Response to Planning Application

From: Arun District Council Greenspace

Application ref: Y/186/21/PL

Location: Bonhams Field Main Road Yapton BN18 0DX

Figure 1: Masterplan and Red Line Boundary (OSP, 2021)

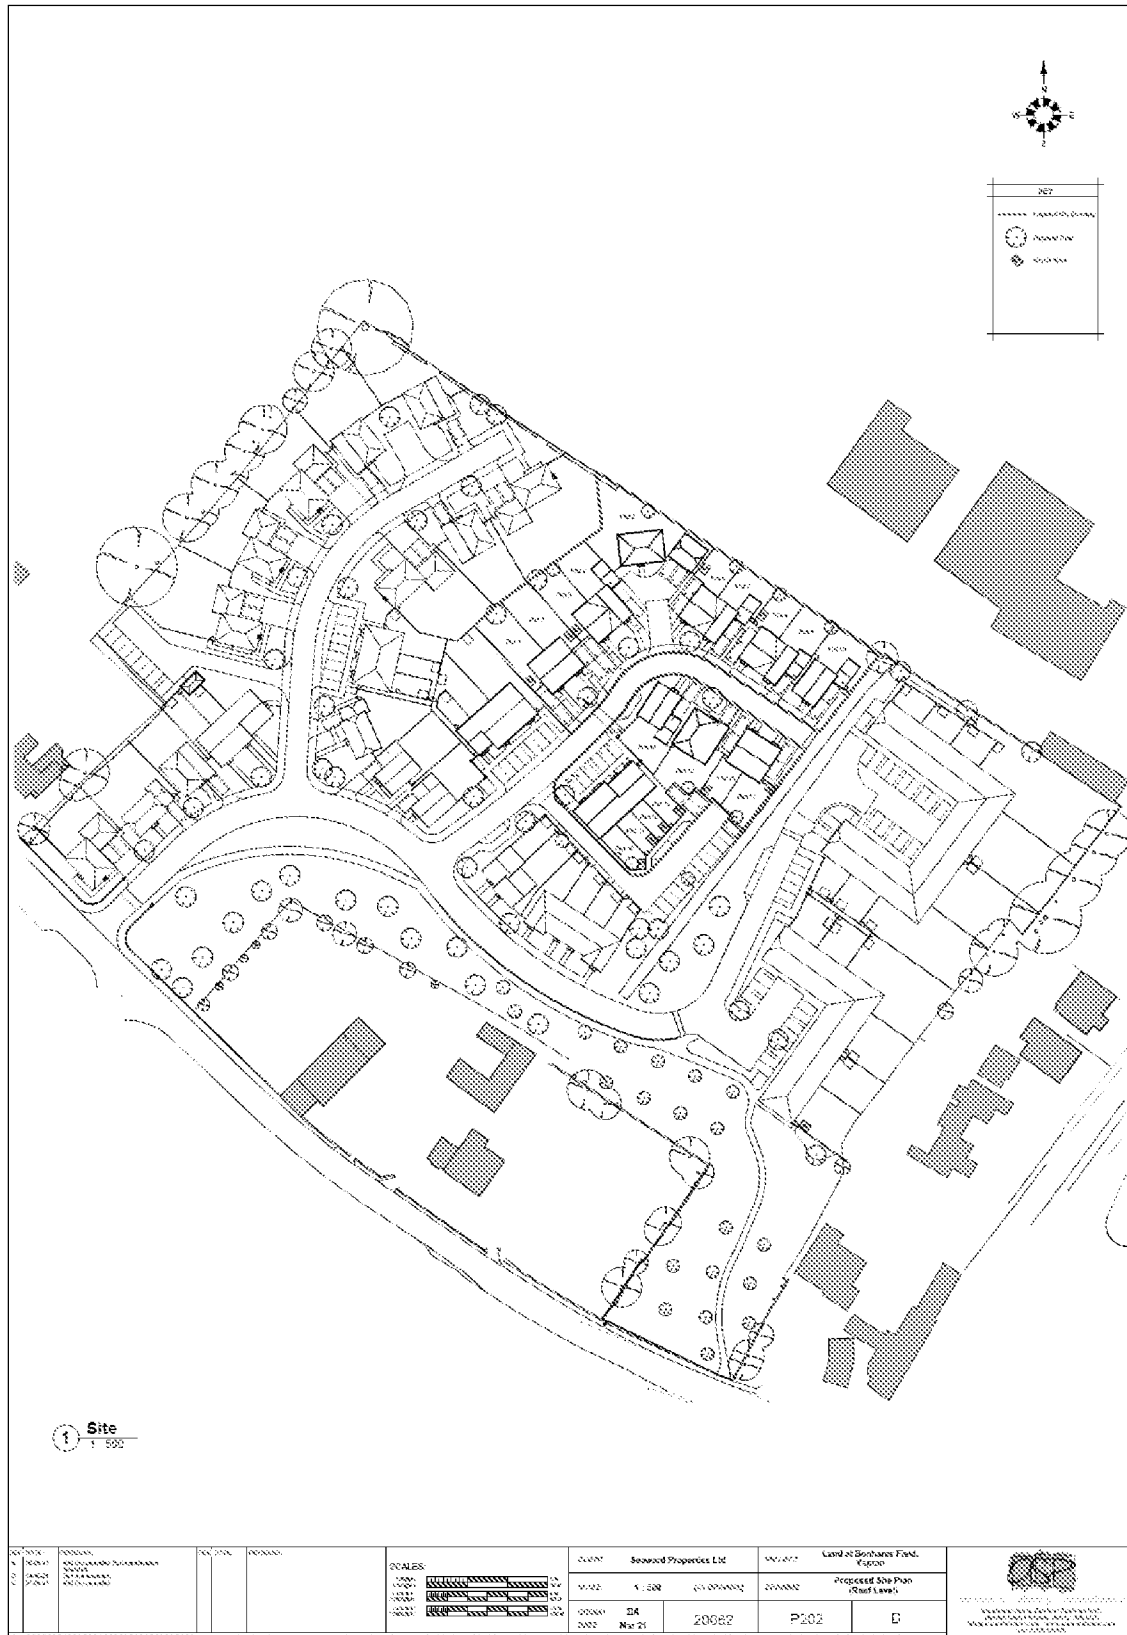
I would advise that the 32 dwellings in the shown red line area looks very cramped and over developed, particularly in the north/west portion of the site which now accommodates many of the smaller additional units. The proposals presented in this application Y/186/21/PL and the previous application Y/98/20/PL appear detrimental in design layout to those approved in outline Y/1/17/OUT where I reference the layout plans submitted at that time and my comments of 16/05/17.
